WEST SUSSEX COUNTY COUNCIL CONSULTATION

TO:	Arun District Council FAO: Ms Myer
FROM:	WSCC - Highways Authority
DATE:	4 August 2021
LOCATION:	Land to rear of Birchwood House Church Lane Barnham PO22 0DB
SUBJECT:	BN/97/21/PL Retention of existing site entrance (resubmission following BN/110/20/PL). This site is in CIL Zone 3 (Zero Rated) as other development.
DATE OF SITE VISIT:	n/a
RECOMMENDATION:	More Information
S106 CONTRIBUTION TOTAL:	n/a

Drawing Details	
Photographs of site access	
Planning Issue	
Drawing No. C0117-P014	Date September 2020
Scale -	Revision -

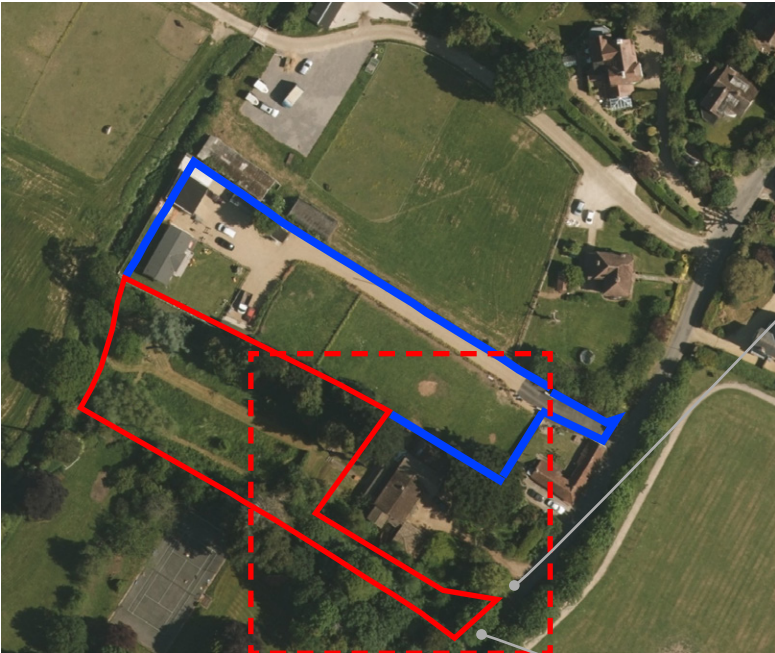
The Local Highways Authority does not have any evidence to conclude that there has been an access at this location prior to the works.

As such the adequacies of the access will be assessed as if it was a new point of access onto the maintained highway network, using current guidance and standards.

The access is to serve a parcel of land that in the application form is listed as being occupied by donkeys and a small stable. In order to establish a base line, position the applicant should detail how the parcel has been being accessed in the recent past. Or was this parcel of land previously inaccessible?

No plans have been submitted to demonstrate the maximum achievable visibility splays at the access point. These splays should be drawn as per the principles of manual for streets and only require land either under control of the applicant or that considered public highway.

Further guidance on how to draw the splays can be provided directly to the applicant if required. Splays should also be demonstrated for the existing access arrangements once those have been established as per comment above.
